**CITY OF ALBUQUERQUE
ADMINISTRATIVE APPROVAL (AA)- SITE DEV PLAN AMENDMENT
ROUTING & REVIEW SHEET**

APPLICATION #: 11 AA 10136	PROJECT #: 1003883
PROJECT NAME: 7425 Jefferson NE	
APPLICANT or AGENT: D/P/S Design	
PHONE # and E-MAIL: 761-9700 Sheri	
ZONE ATLAS PAGE: D-17	
ADMINISTRATIVE APPROVAL (AA) for:	<input type="checkbox"/> EPC CASE <input type="checkbox"/> DRB CASE

Re: Journal Center Phase 2, Unit 2, Tract 9A-1A-1
DRB Site Development Plan for Building Permit Administrative Amendment
Project #1003883

- ▲ 12/21/11 Admin. Amend.
- ▲
- ▲
- ▲ cmj 11-23-11 tree & shrub moved

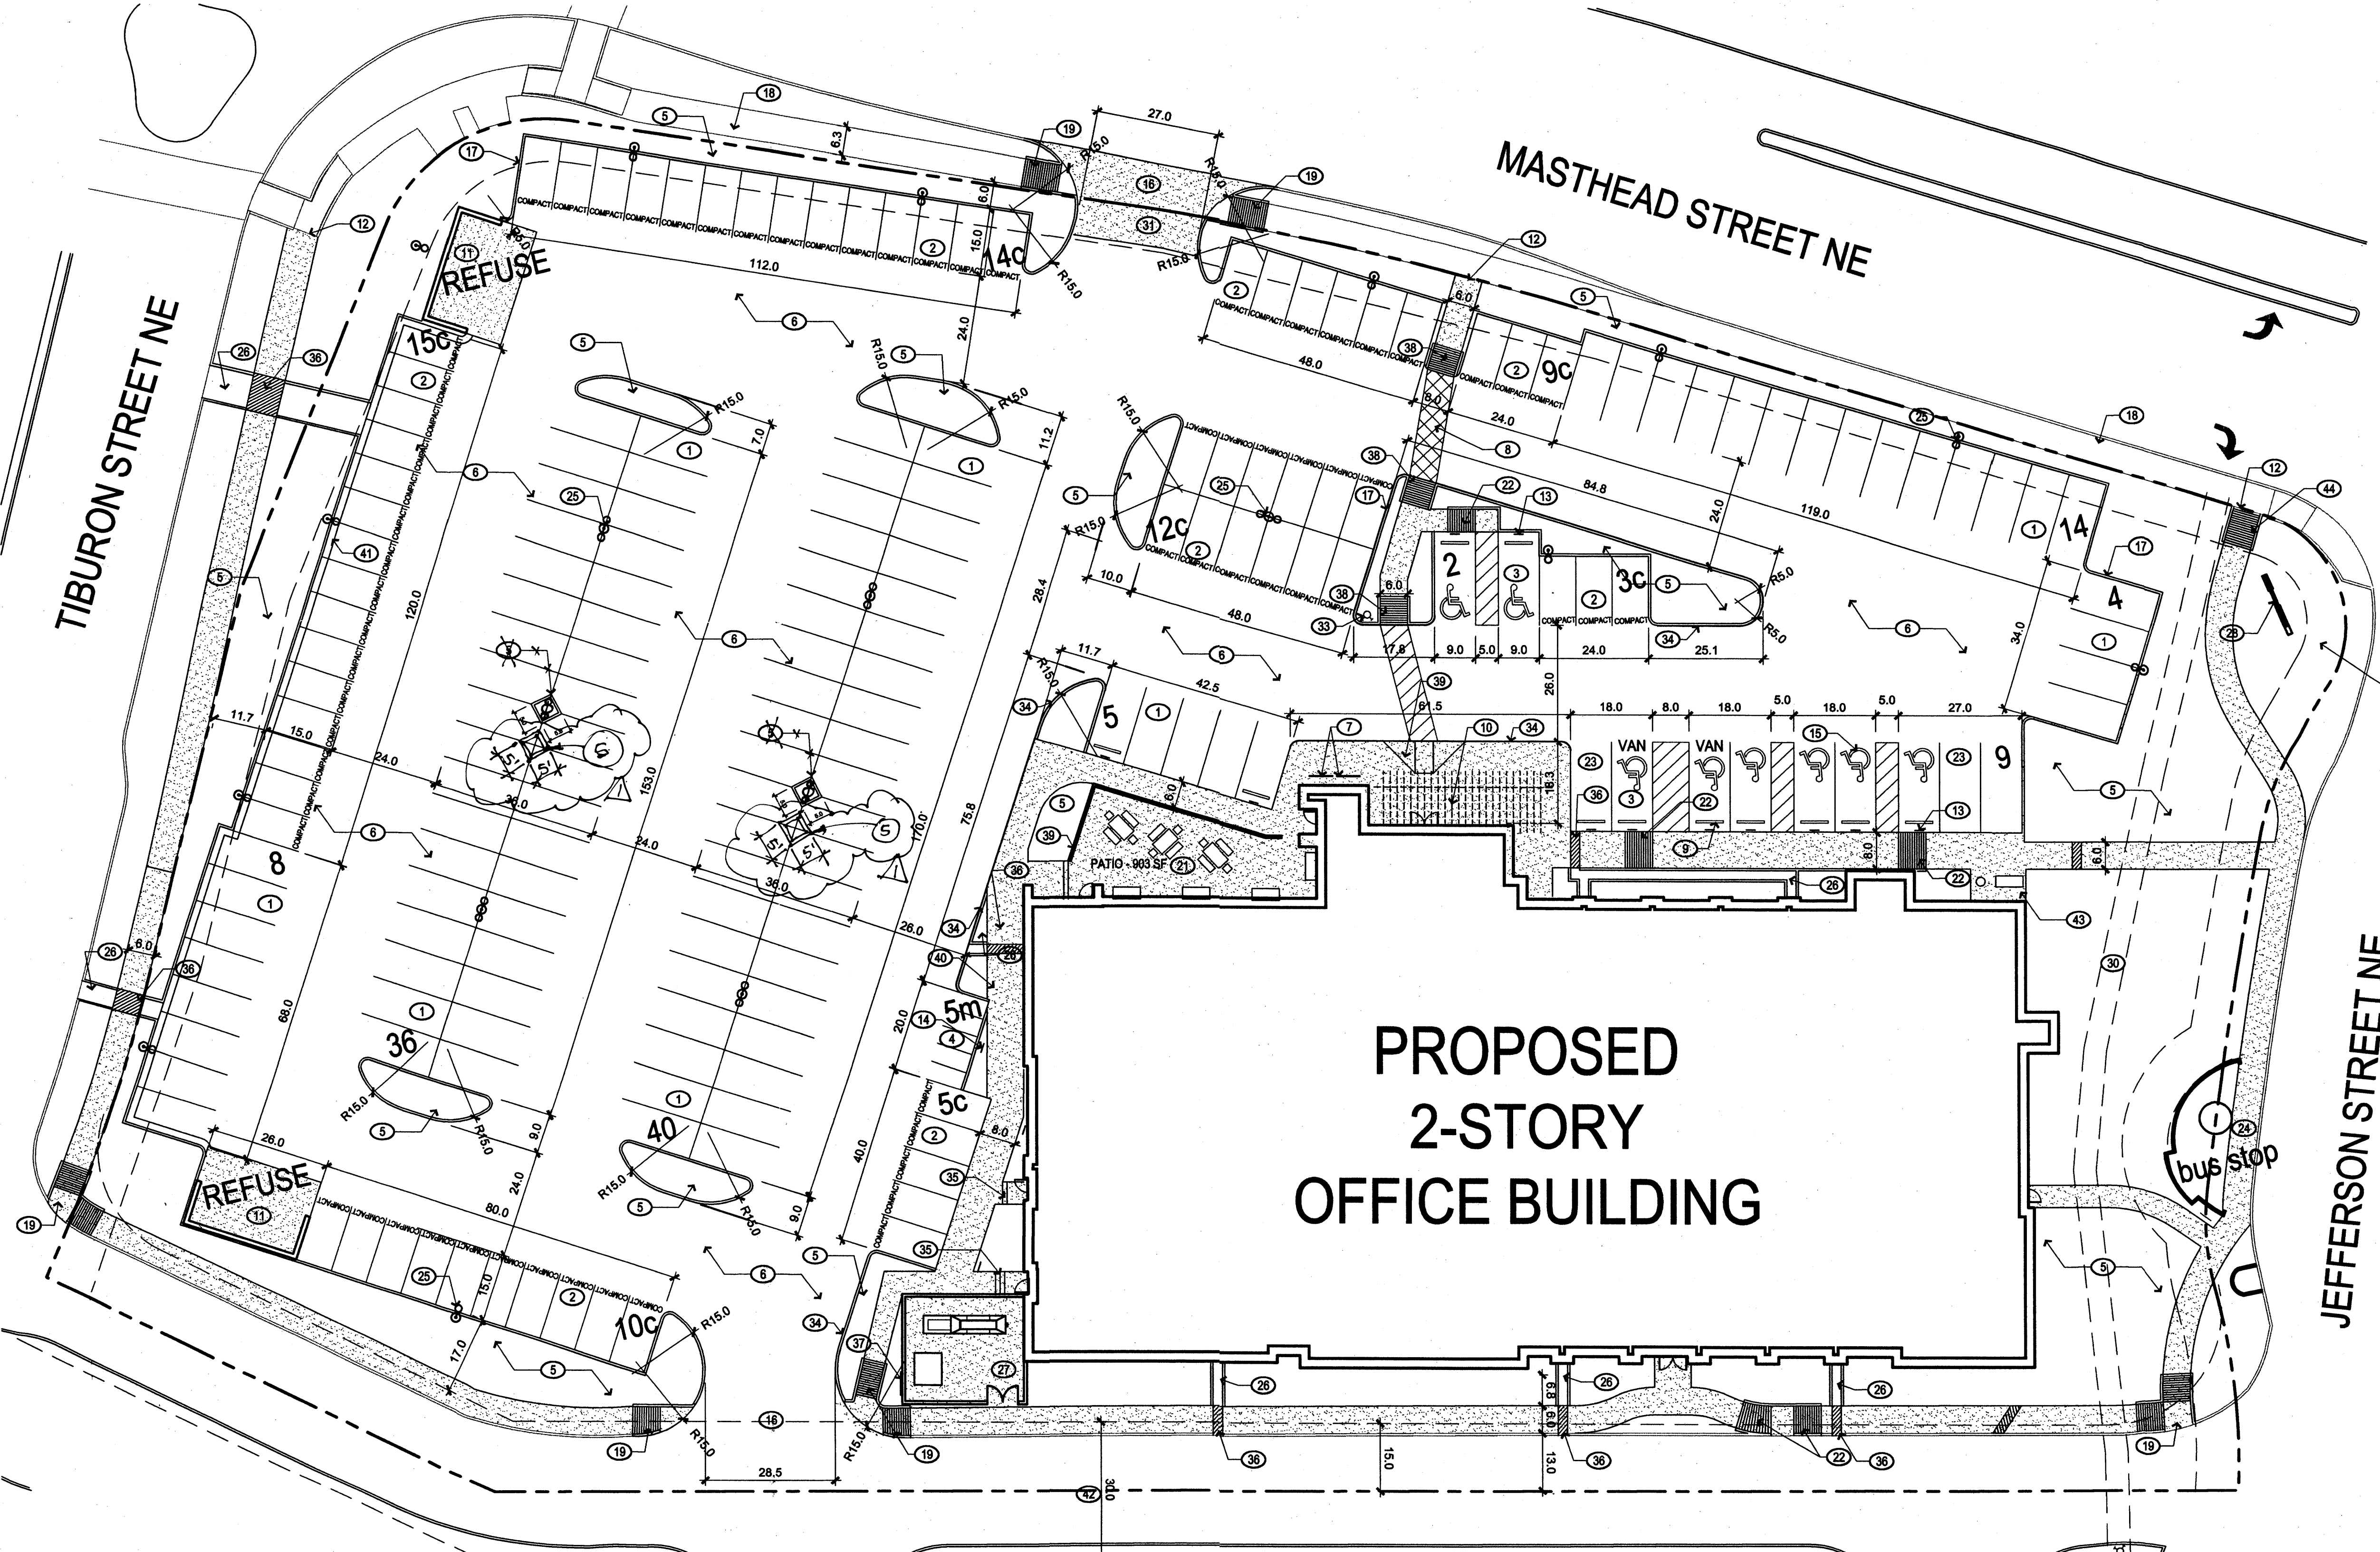
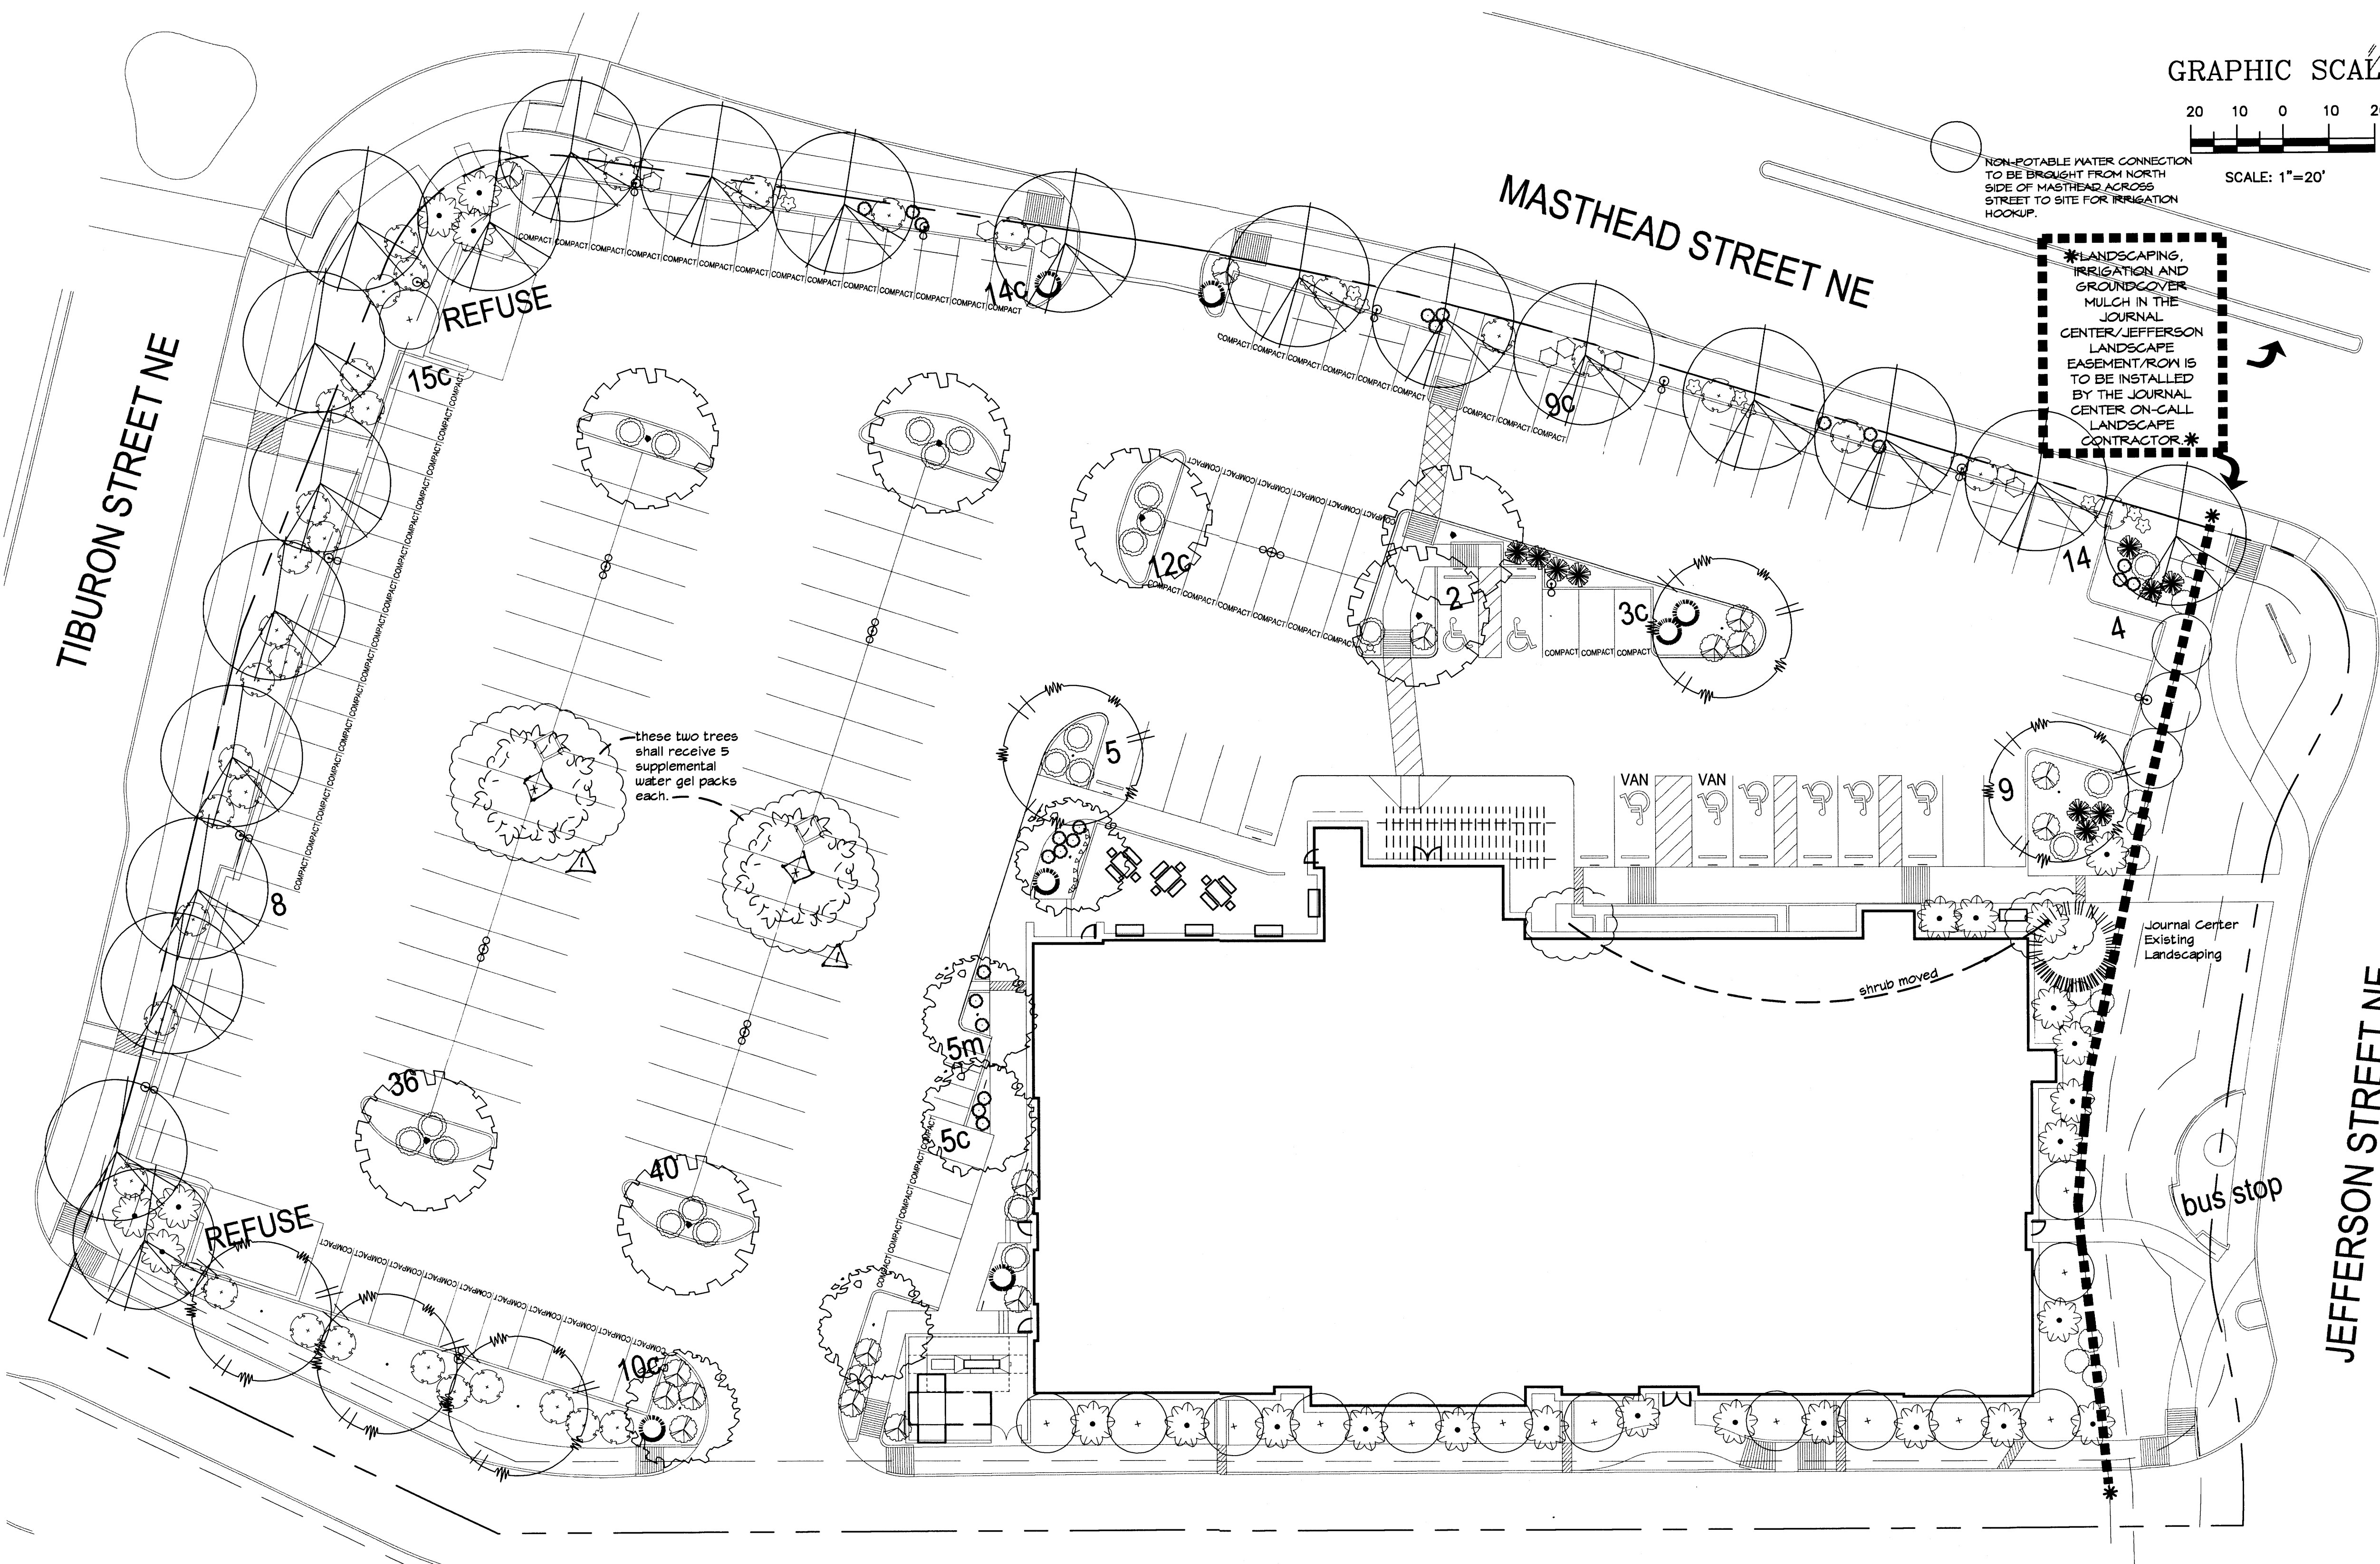
The proposed revision indicates where lighting was added to the parking field to provide adequate illumination for safety purposes. The optimum locations were tree wells where landscaping had been planned. The revised site plan for your review indicates relocating the tree wells to the south, nine feet from the original location.
